## **Save Honey Hill comments on submissions made at Deadline 4**

## CWWTPR DCO Examination

## Submission by Save Honey Hill Group

**Response to the draft Design Code 7.17 [REP4-085]**

**Figure 3.14 Carbon Reduction commitments and aspirations**

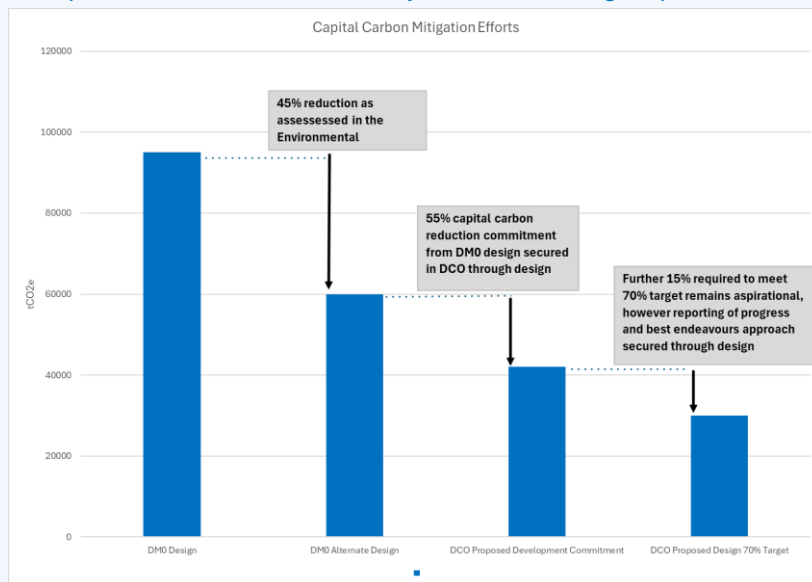
- 4.1. The Applicant has now confirmed that the total carbon construction emissions of the DCO Design as it stands is 53,010 tCO<sub>2</sub>e, a claimed 45% reduction on the DM0 Design. The Applicant has set out briefly in the carbon section of the Design Code [REP4-085] how it is making a commitment to reduce those emissions further to a -55% reduction to 43,540 tCO<sub>2</sub>e with an aspiration to go further to achieve the Applicant's stated corporate commitment of a -70% reduction.

- 4.3. It is difficult to judge whether the 55% reduction target is reasonable, since we do not have access to the detailed assumptions being made as to the potential sources of further reductions or how these will be imposed through the Applicant's supply chain. Based on other projects at this stage of design, a further 20% or so reduction, to 34,800 tCO<sub>2</sub>e is likely to be achievable. The Applicant's own corporate -70% reduction target may not be.

- 4.4. SHH would prefer that these arrangements were captured in a Design and Construction Carbon Management Plan and a separate DCO Requirement, alongside Requirement 21, dealing with operational carbon. Further comments on this are set out in SHH 53 Response to the draft Design Code [REP4-085].
